Your Ref :
Our Ref : FP/190/15/NMA

Section 96A of the Town & Country Planning Act 1990 (as amended)
Town and Country Planning (Development Management Procedure) (England) Order 2015 (as amended) - Article 10
Application for a non-material amendment following a previously approved planning application
FP/208/08 relating to re-location of waste bins spaces & reduction of some windows sizes and
adjustment of positions
109a Felpham Way, Felpham, .

Drawn by: P. O' NEILL	Date: OCTOBER, 1998
Scale/s 1:100, 1:500, 1:1250	
Drg. no. 9836 / 02	Rev. L

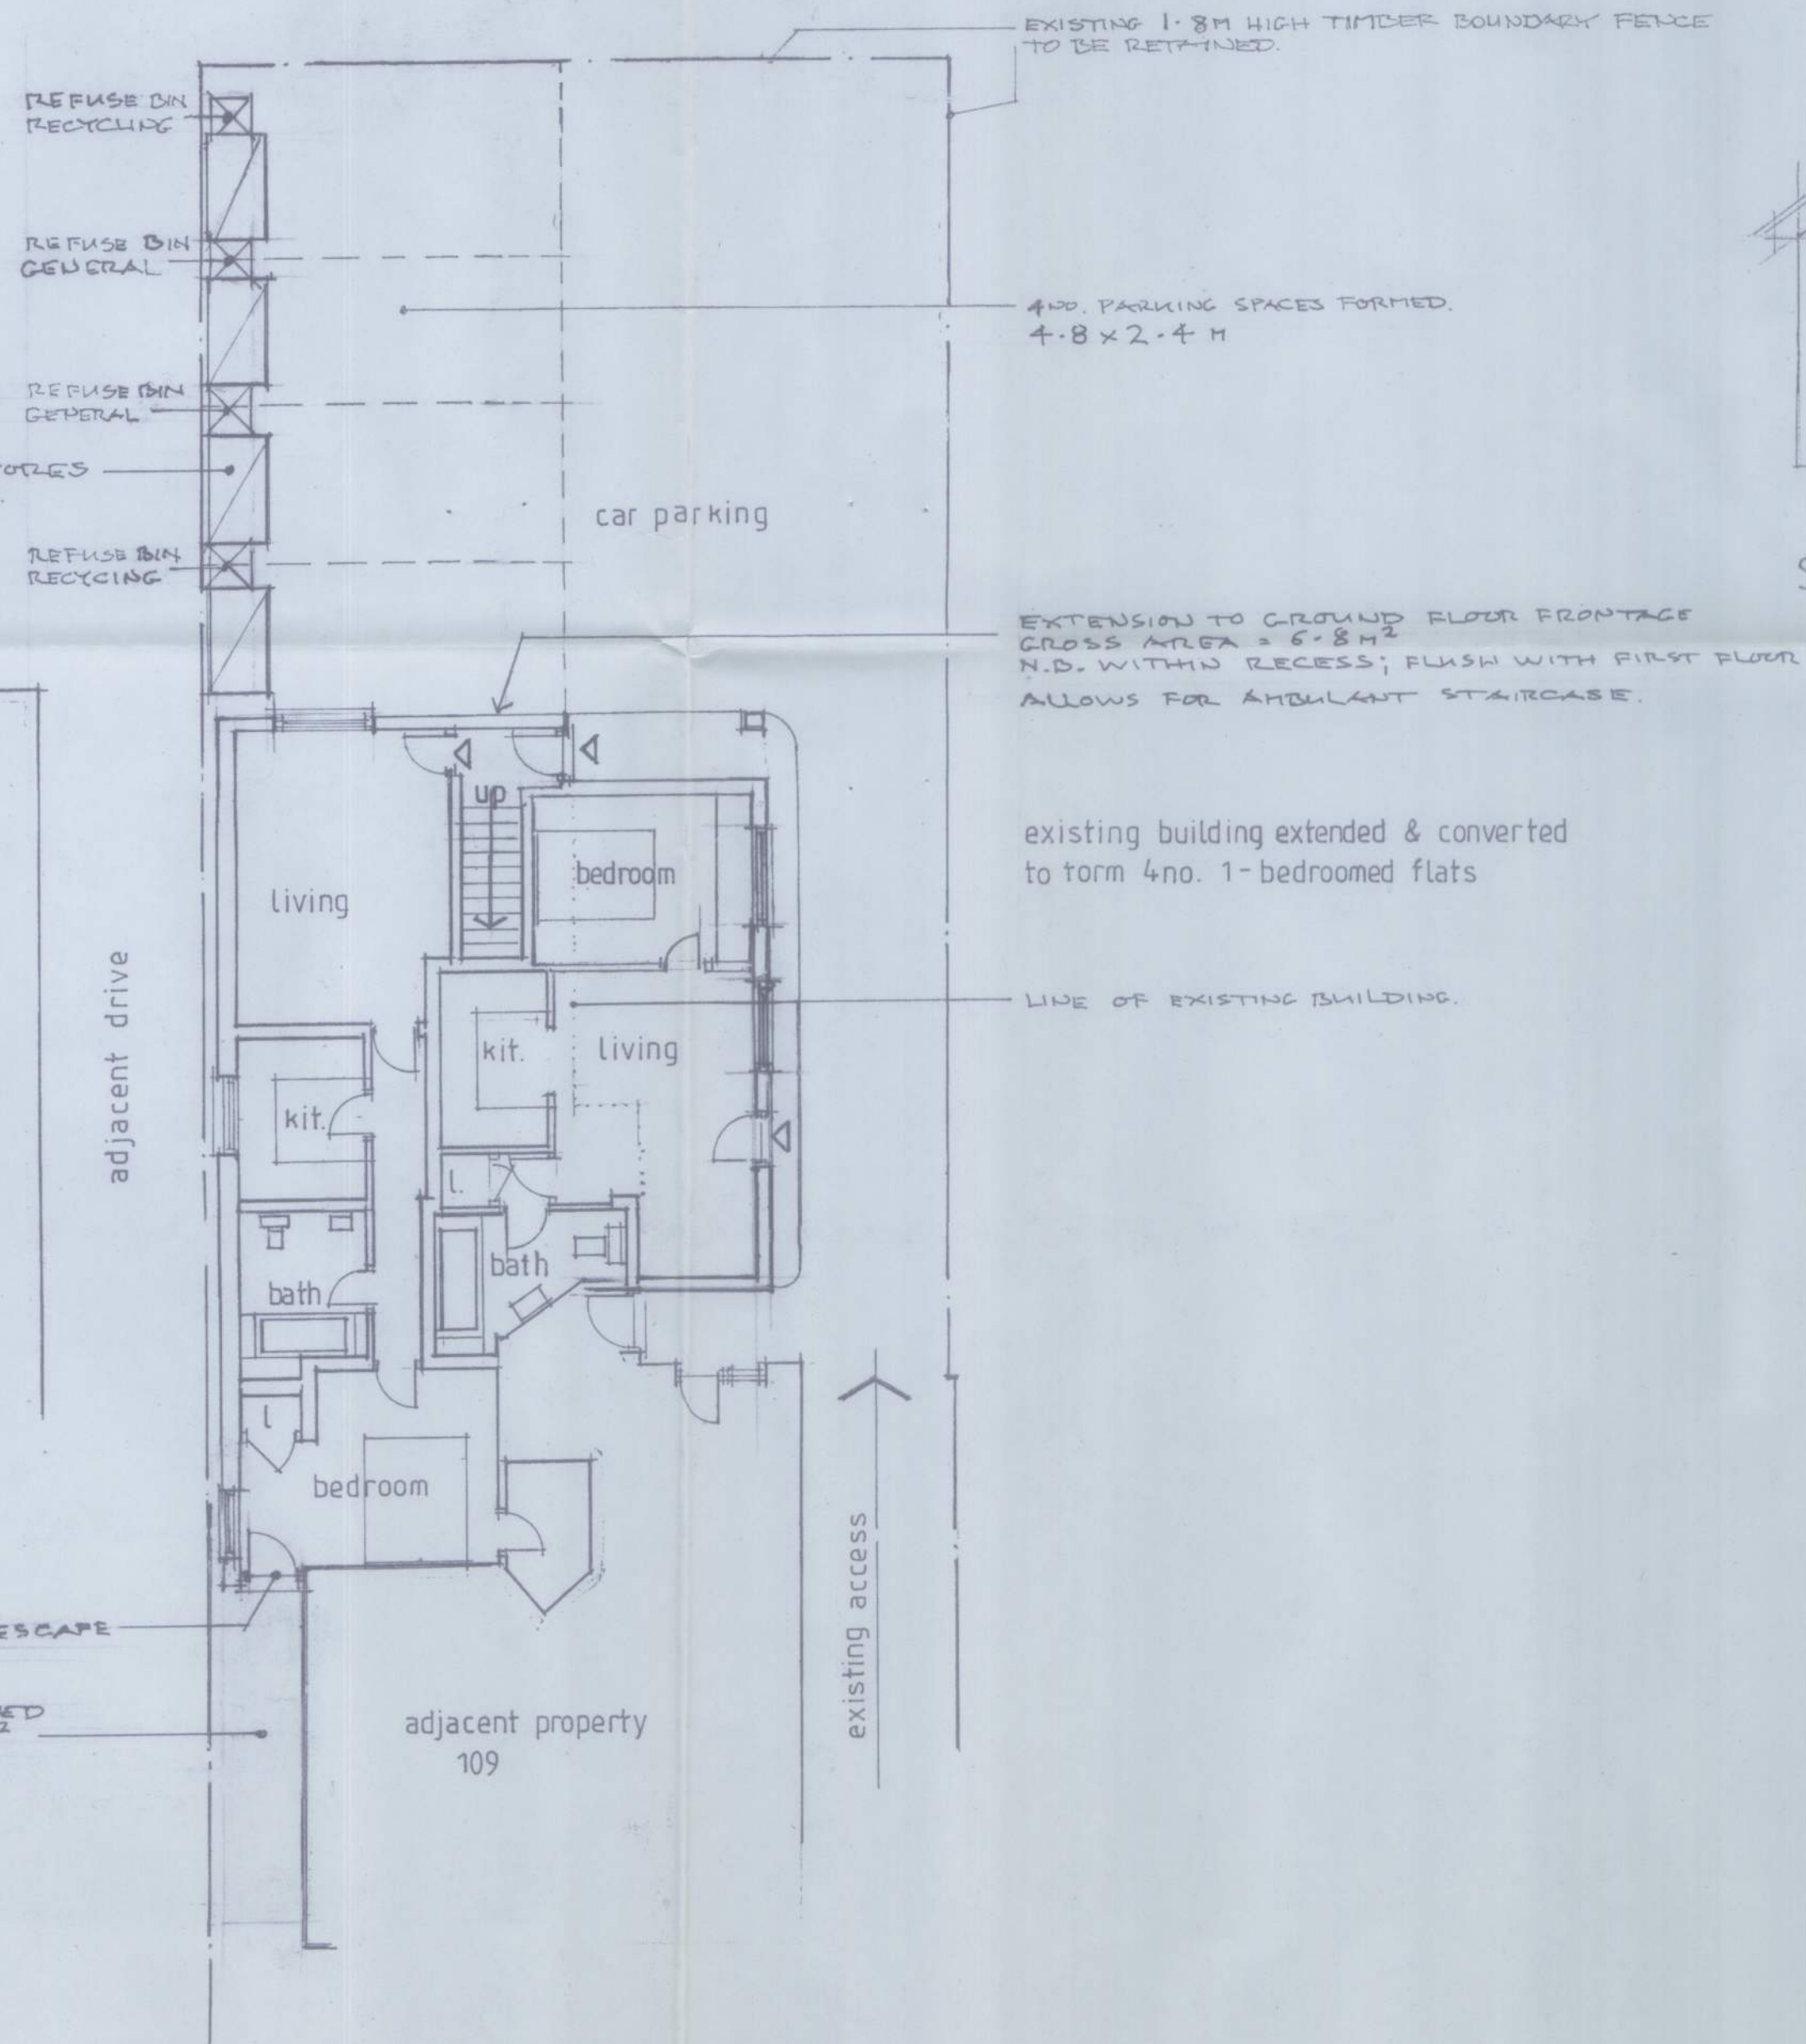
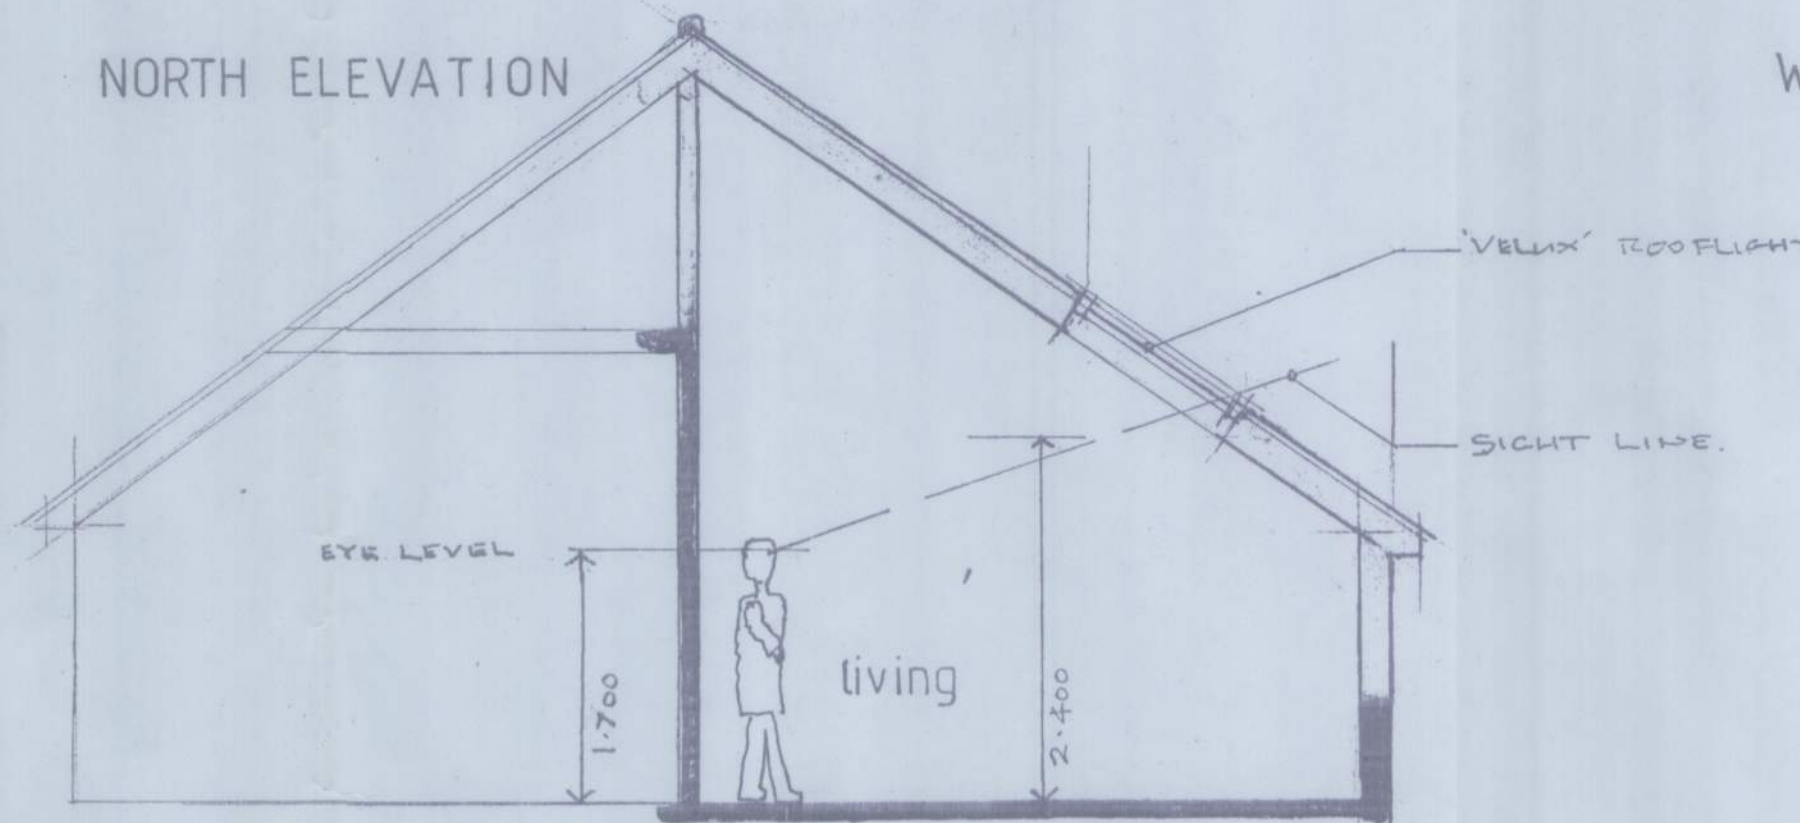
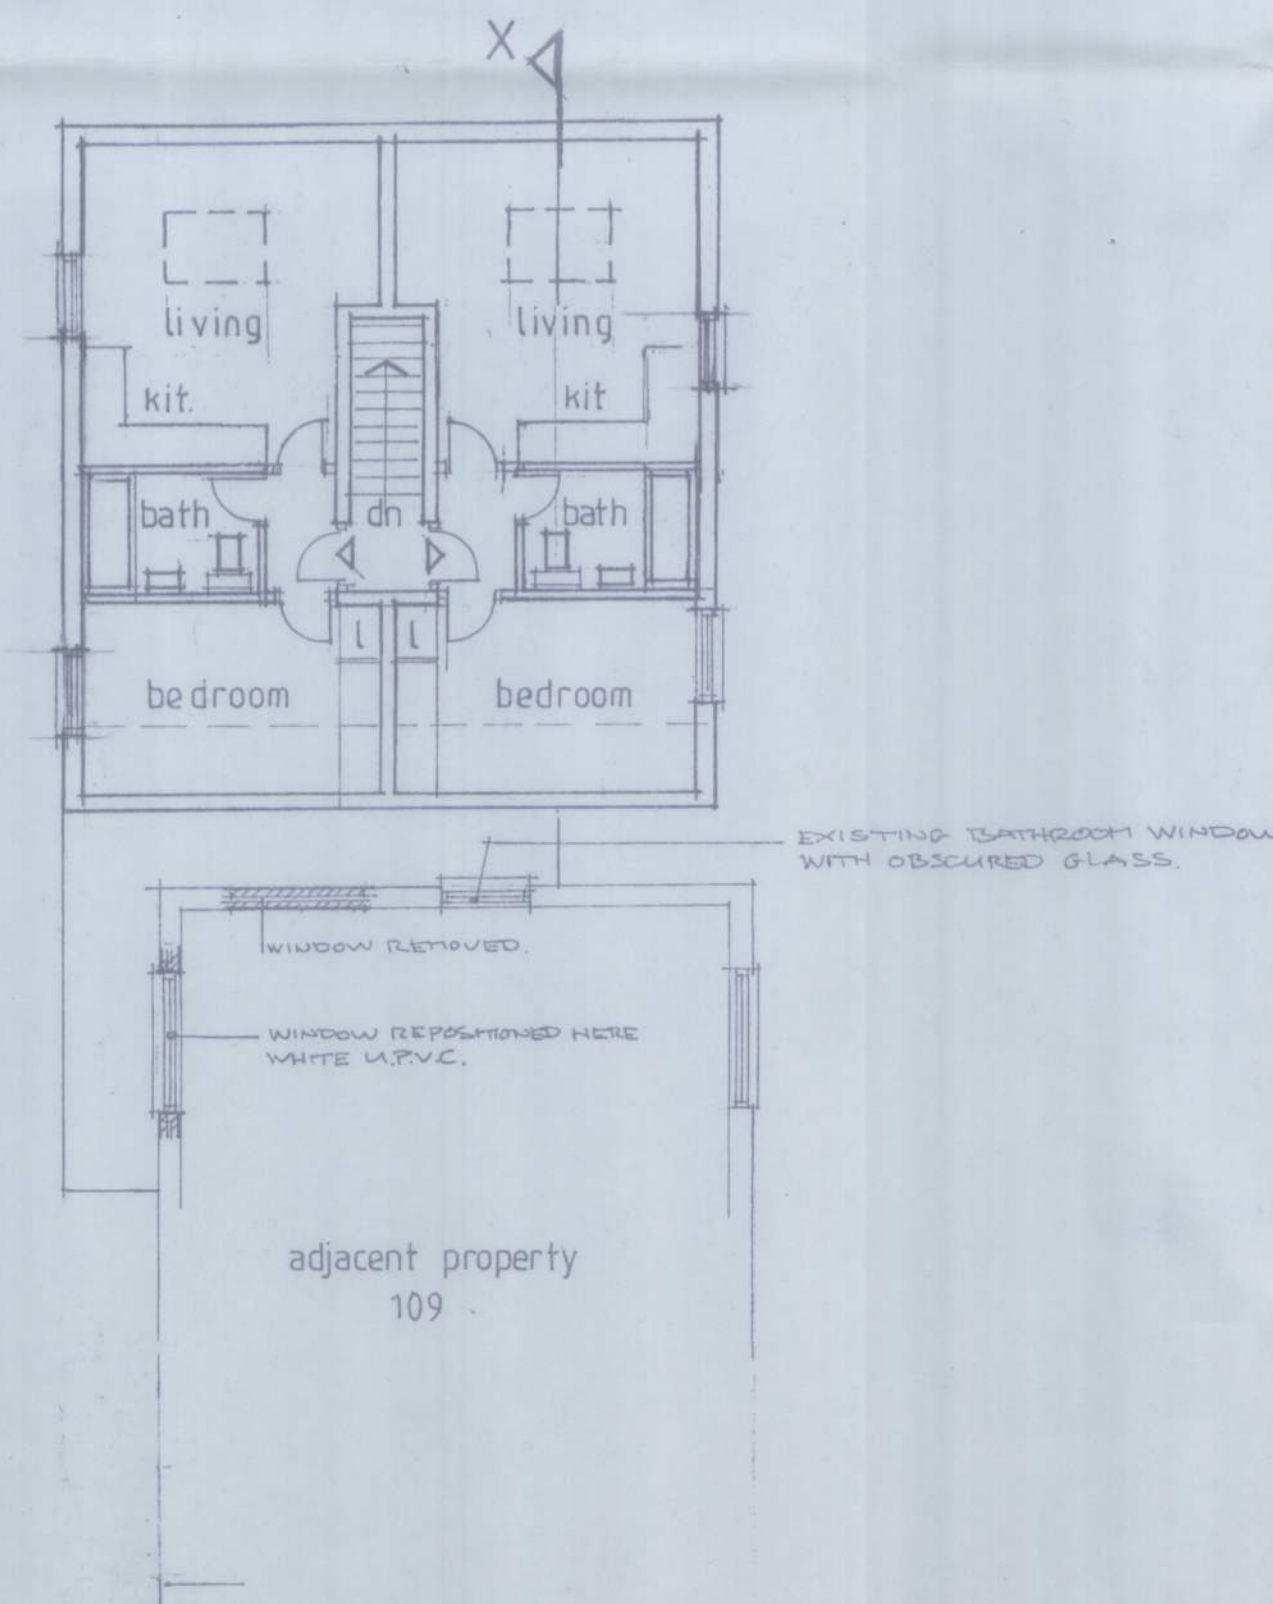
The proposed amendments relate to a changes to the location and size of windows, relocation of waste bins and inclusion of cycle storage.

These changes will be accepted as Non Material Amendments to the previous planning approval.
